RE: AU-25-00003 Merten – Request for Additional Information

Kittitas County Community Development Services (CDS) received your Accessory Dwelling Unit (ADU) Application on January 29th, 2025, to permit the existing manufactured home as an ADU in order to construct a new Single-Family Residence (SFR) on parcel #239433.

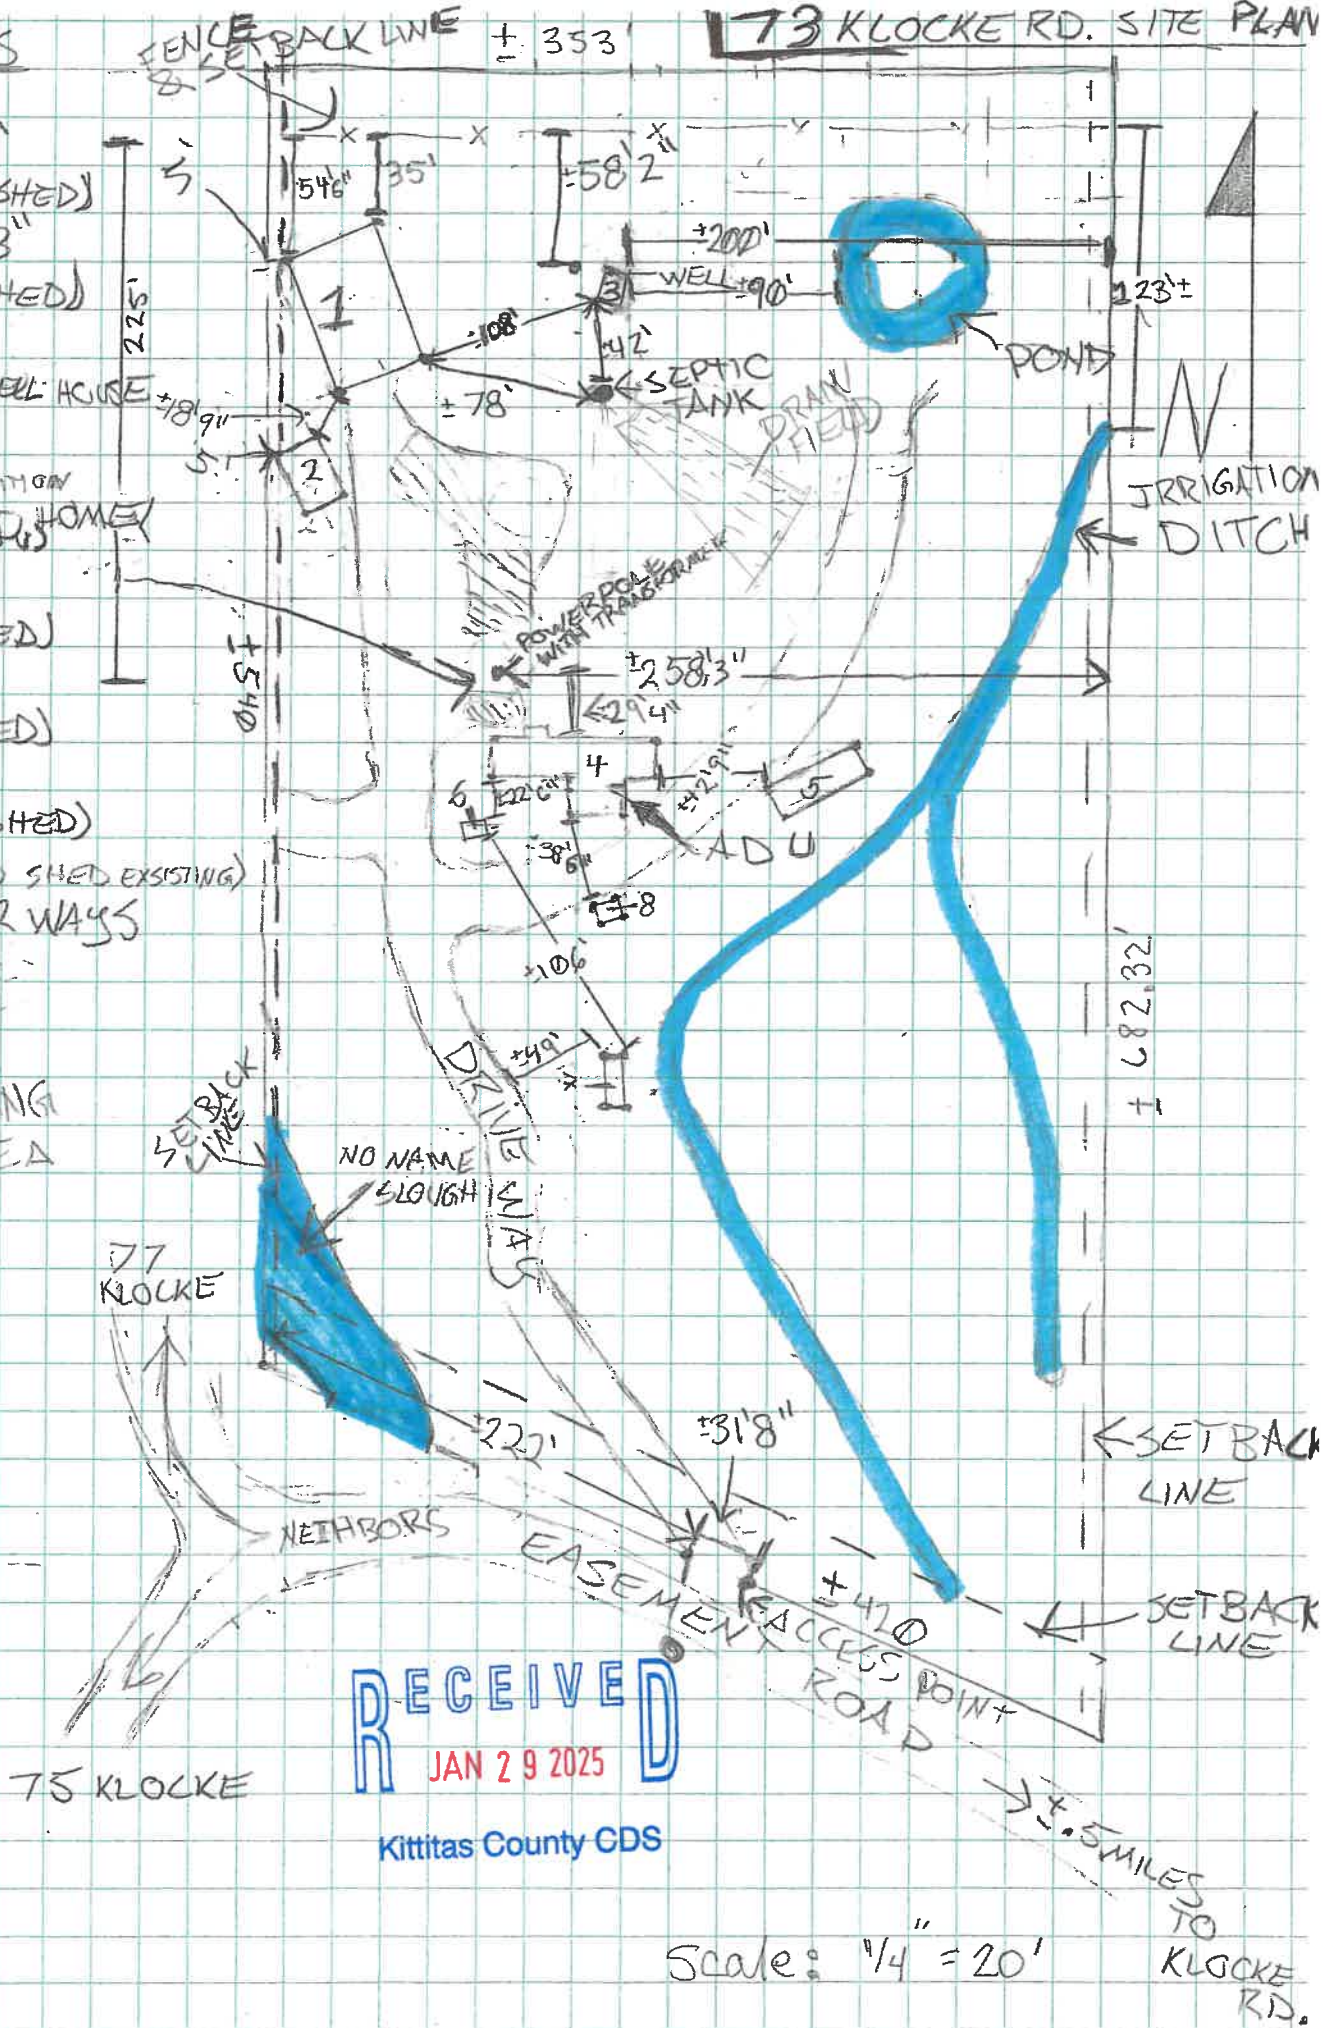
- a) A scaled site plan showing lot area, proposed/existing buildings, setbacks, points of access, roads, parking areas, water system components, septic tank, drain field, drain field replacement area, areas to be cut and/or filled, and natural features (i.e. contours, streams, gullies, cliffs, etc.)
- i) **The Site Plan should include the location of the proposed SFR in addition to the information provided.**
